ALLWEST LLC PERFORMANCE BASED CLUSTER PLAT

TO: Kittitas County Hearing Examiner
FROM: Kittitas County Community Development Services Staff
RE: Allwest LLC Performance Based Cluster Plat (CL-09-01)
DATE: December 8, 2011 Hearing

Requested Action: Chris Cruse, authorized agent for Allwest LLC, property owner, has applied for a performance based cluster plat to subdivide a 50.58 acre parcel into sixteen (16) one-acre lots and one 34.51 acre open space lot. The project is proposed to be served by a Group B water system and individual on-site septic systems.

ALLWEST LLC PLAT
PART OF SECTION 7, T. 17 N., R. 18 E., W.M.
KITITAS COUNTY, WASHINGTON
- PRELIMINARY PLAT -

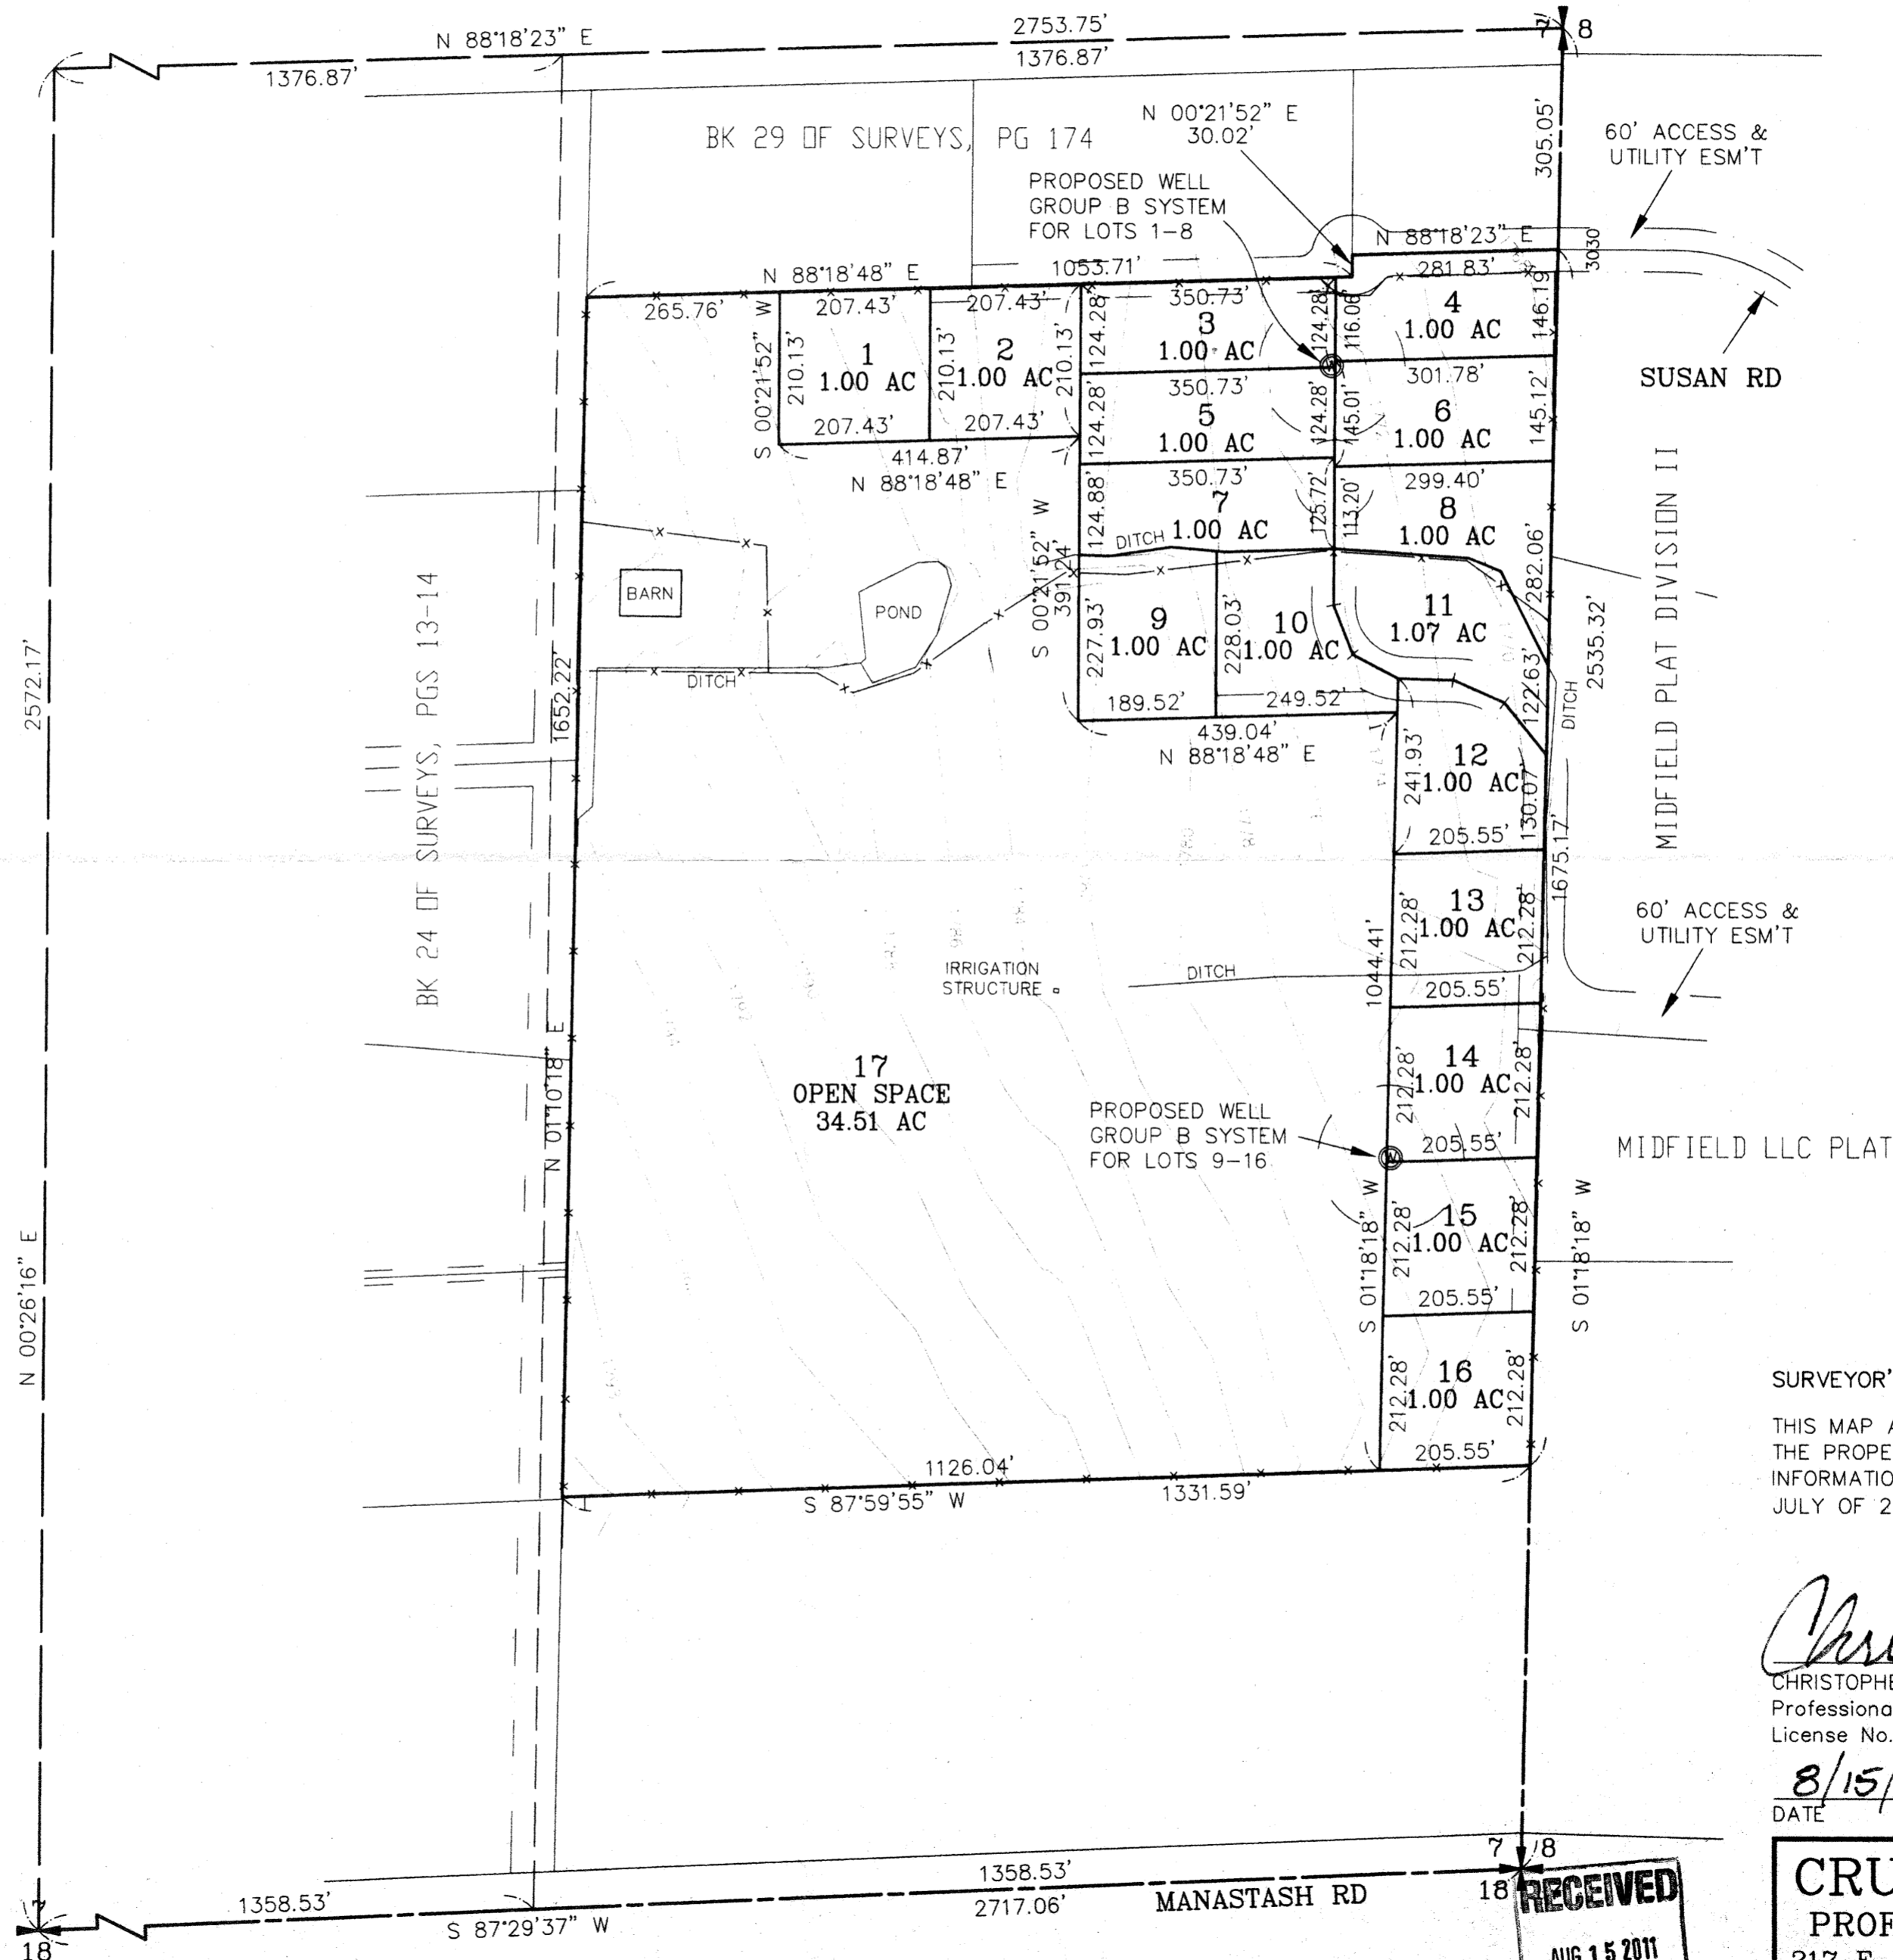
Private Road Improvements – Midfield Drive: Access from Manastash Road to the final cul-de-sac shall be constructed to meet or exceed the conditions of a High-Density Private Road that serves 15-40 tax parcels. See current Kittitas County Road Standards, 9/6/05 edition.

- a. Access easements shall be a minimum of 60' wide. The roadway shall have a minimum width of 22', with 1' shoulders, for a total width of 24'.
- b. Minimum centerline radius shall be 60'.
- c. Surface requirement BST/ACP.
- d. Maximum grade is 12%.
- e. Stopping site distance, reference AASHTO.
- f. Entering site distance, reference AASHTO.
- g. Maintenance of driveway approaches shall be the responsibility of the owner whose property they serve. The County will not maintain accesses.
- h. Any further subdivision or lots to be served by proposed access may result in further access requirements.

- a. To serve lots 1 and 2, the road must be extended and a new cul-de-sac constructed in the vicinity of lot 2. No more than two lots can be served by a driveway off the end of a cul-de-sac.
- b. Per the findings of Road Variance 11-08, the private portion of Susan Road must be verified to be 20' wide, including gravel and pavement, through the road certification process. The road extension may be constructed to 20' wide.

Cul-de-Sac: A cul-de-sac turn-around having an outside right-of-way or easement diameter of at least 110 feet shall be constructed at the closed end of all dead-end roads serving 3 or more lots. The driving surface shall be at least 96 feet in diameter. Cul-de-sacs must also conform to the requirements specified by the 2009 International Fire Code. Contact the Fire Marshal regarding any additional cul-de-sac requirements.
